An  
Bord  
Pleanála

## Inspector's Report

### ABP-317874-23

Extraction of sand and gravel from quarry. An Environmental Impact Assessment Report (EIAR) and a Natura Impact Statement (NIS) have been submitted.

Restoration Phase 4
Extraction Phase: 5
Years: 8-10

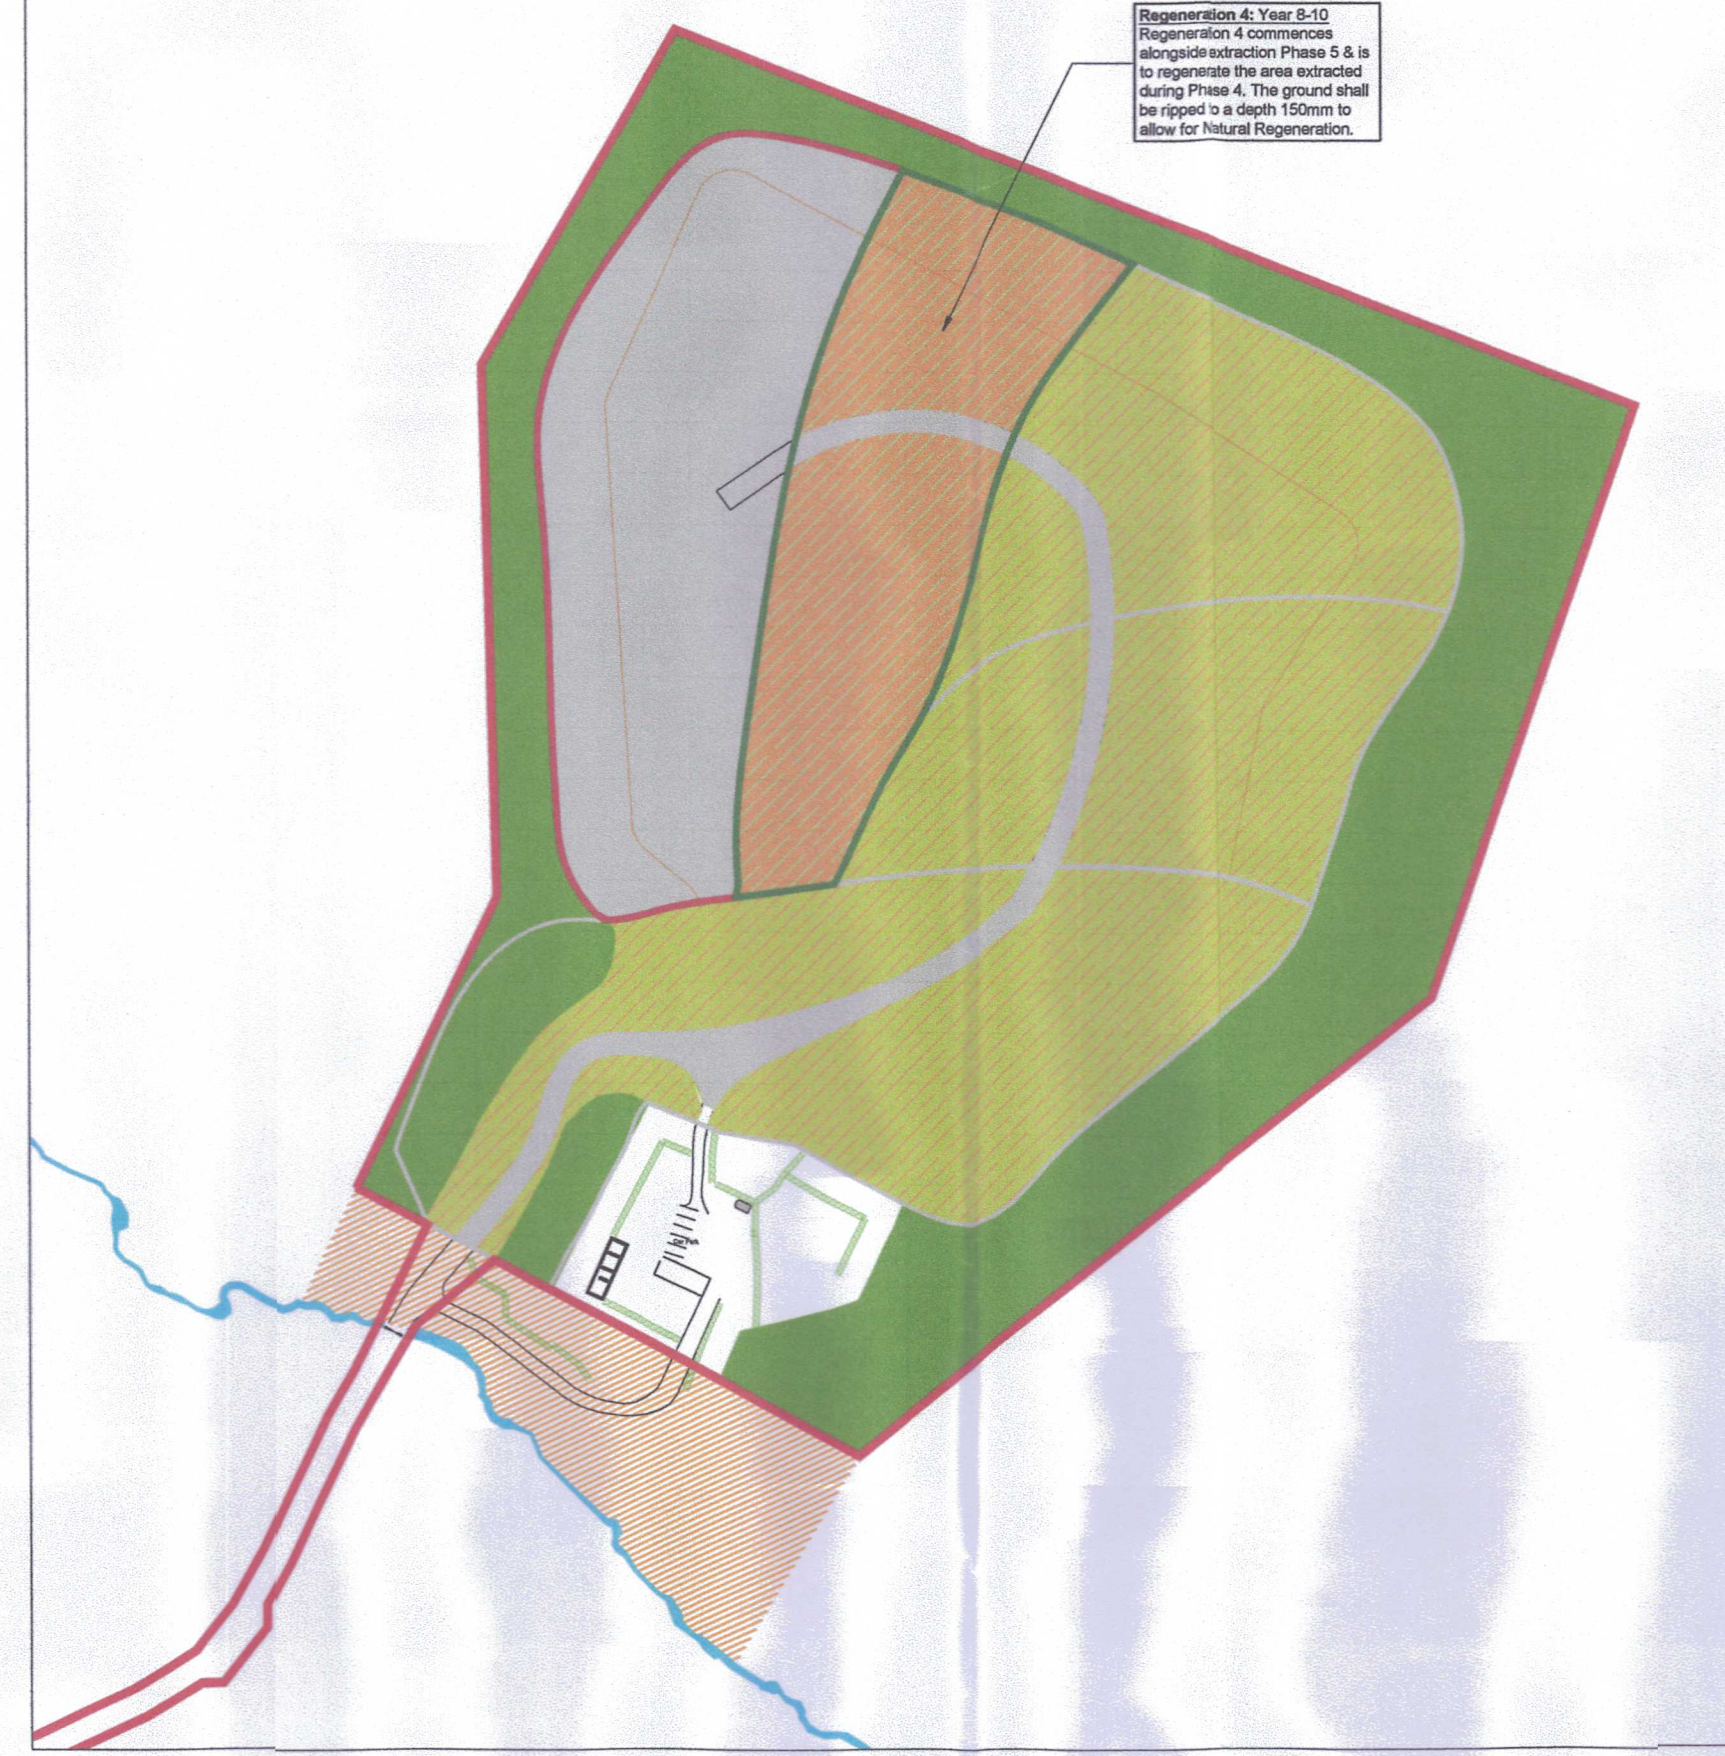
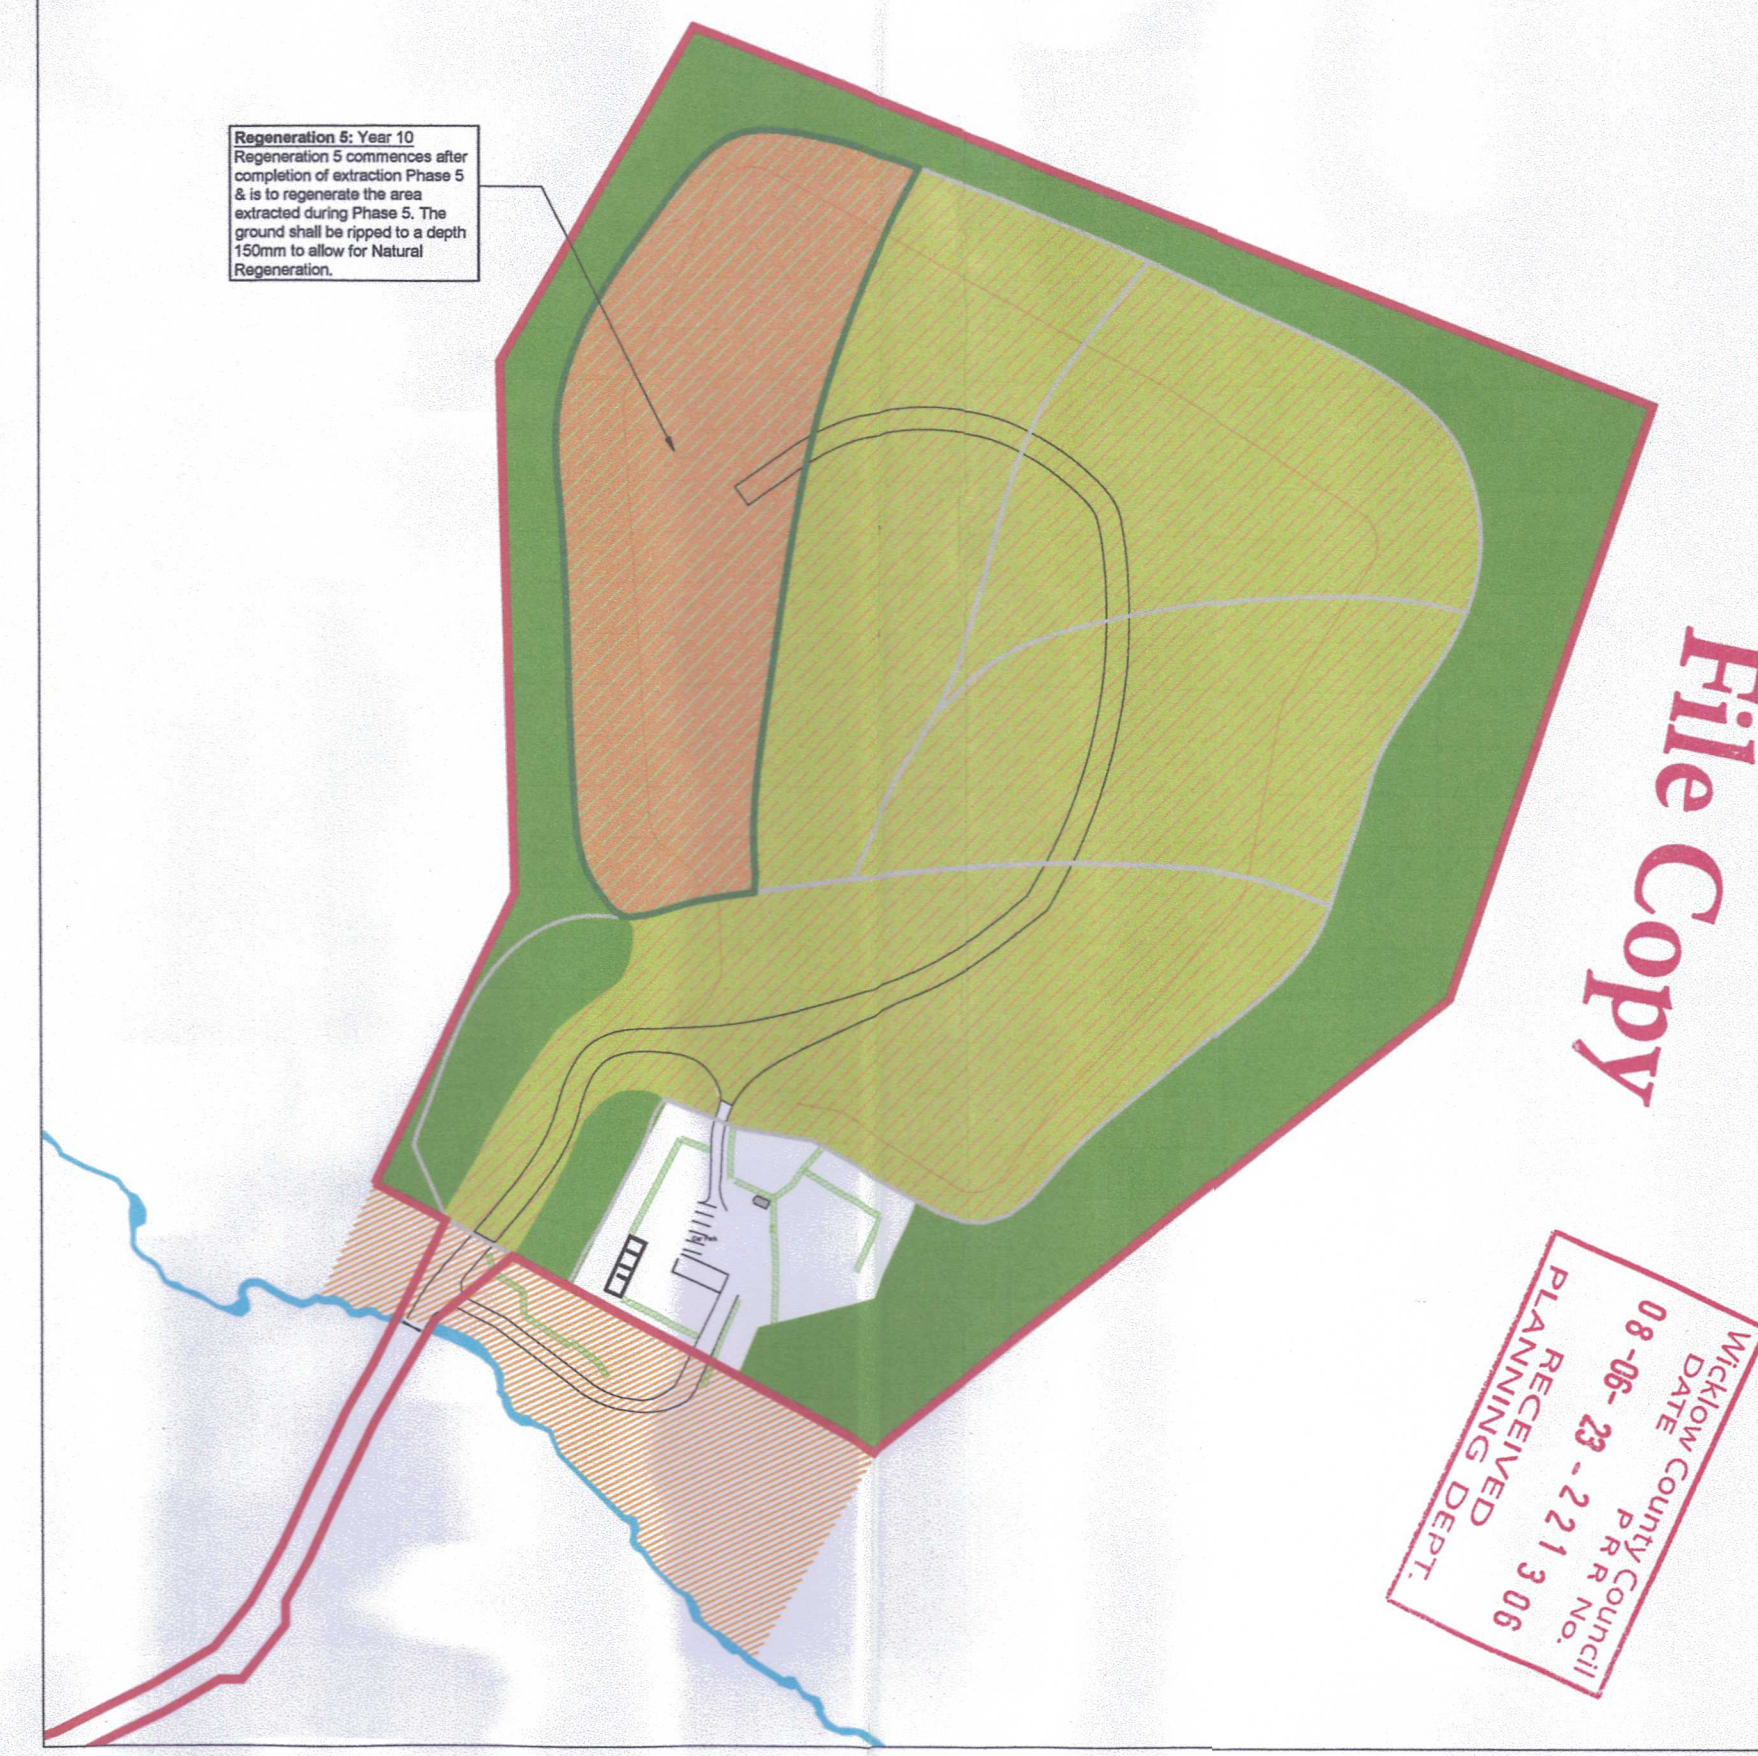
- The Environmental Impact Assessment Report and Natura Impact Statement are deficient in their failure to provide sufficient information/ assessment of the Restoration of the extracted area, which is considered integral to the sand/ gravel extraction. In the absence of such information the proposed development may give rise to significant and adverse effects on the amenities of the area, give rise to a serious traffic hazard, and impact negatively on the environment. The proposed development would, therefore, be contrary to the requirements of the Habitats Directive, to Directive 2014/52/ EU (EIA Directive), to the objectives of the County Development Plan 2022-2028, which seeks to ensure that aggregate exploitation does not unduly impinge on the environmental quality, and the visual and residential amenity of an area. The development would therefore be contrary to proper planning and sustainable development of the area.

3.2.1.4. Within their response document (Part 1), the Applicant noted that there had been a change in the project description, and it was now proposed that restoration activities will be phased and happen concurrently with the phasing of extraction activities. A sequencing of the restoration phase compared to the extraction phasing is set out in Table 2-1 of their response document and they referred to the Updated Restoration Plan that accompanied their response. In addition to the supplementary assessments

PLAN VIEW
SCALE 1:100

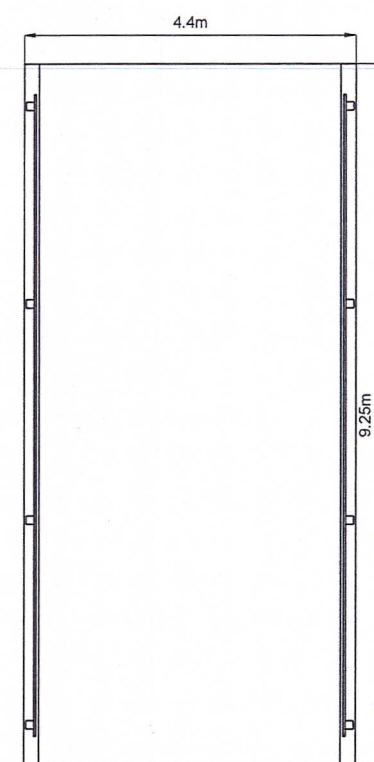
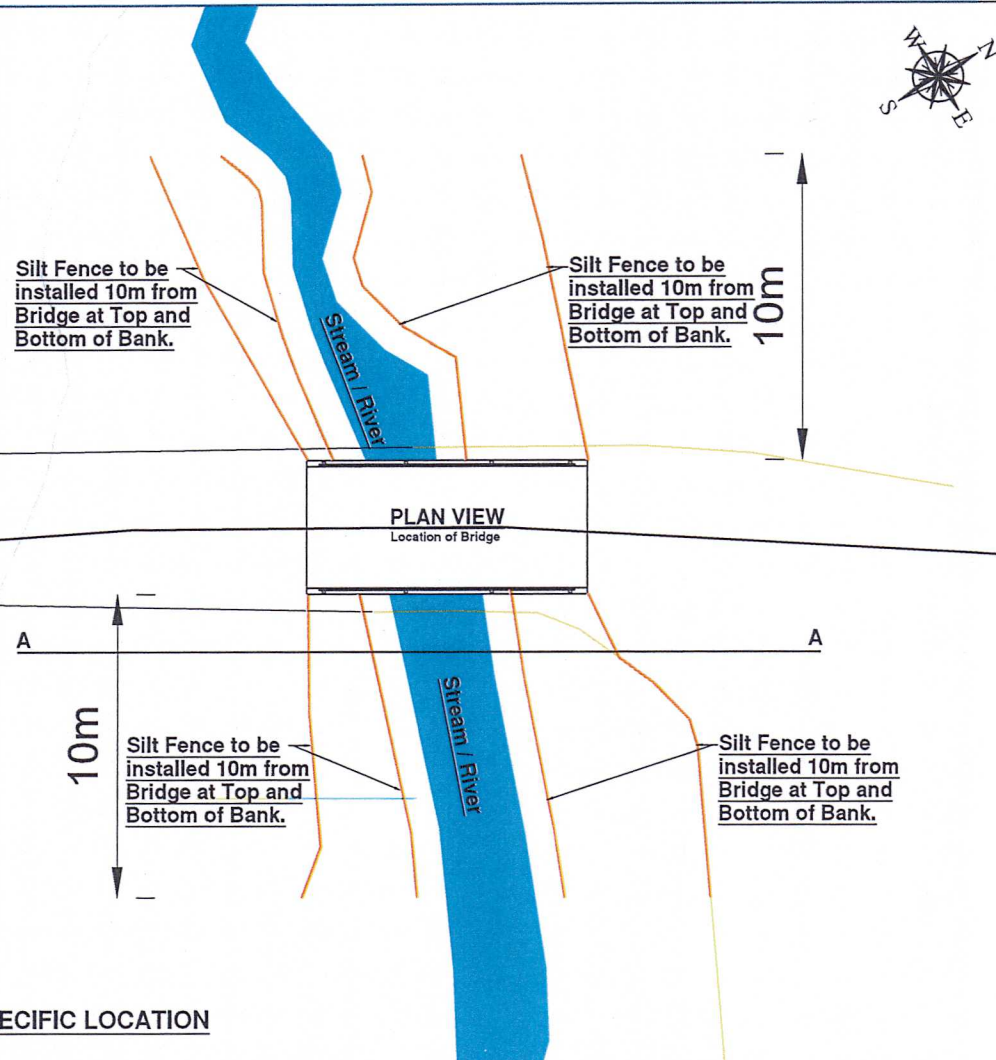
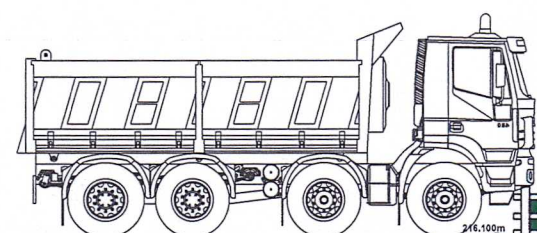
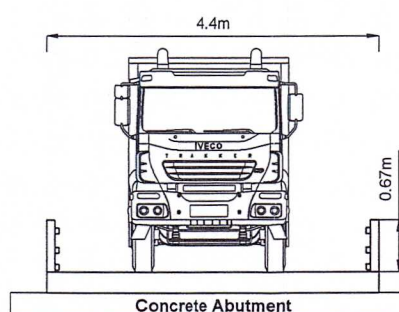
- In terms of the bridge details, it is proposed to install 4x10m lengths of silt fencing upstream and downstream running parallel to the riverbanks at the top and bottom of the bank, in addition to the already specified silt fencing attached to the bridge as originally proposed.
